From: Sharp , Sarah
Sent: 16 January 2020 16:08
To: Tollyfield , Robert
Subject: 2019/1311 - 15 Carr Furlong, Athersley North

As presented I have concerns with the proposed extension to the dwelling. I note that the applicant is proposing to extend the property all the way to the back edge of the footway which is unacceptable. In the instance of any required maintenance to the gable end of the property, it will be necessary to carry out any works directly from the public highway, potentially obstructing the footway and I would recommend a set back of at least 1m from the public highway.

PROPOSED GROUND FLOOR PLAN IN CONTEXT SITE PLAN

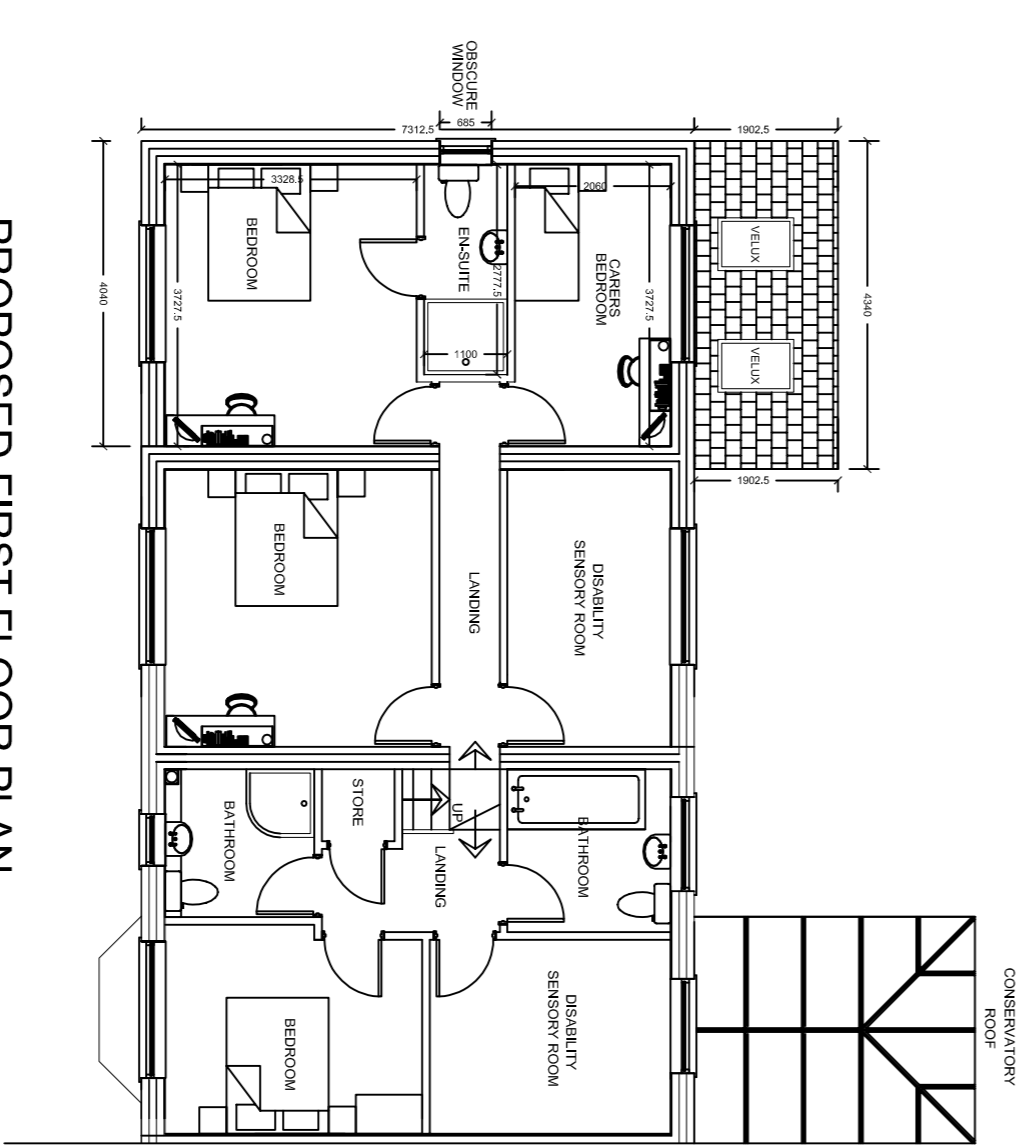
With regards to the access arrangements, it will be necessary to include a 2m x 2m pedestrian intervisibility splay. I note that the existing boundary treatment includes this splay and would not want to see the boundary treatment increased in height or the access amended without the inclusion of this splay.
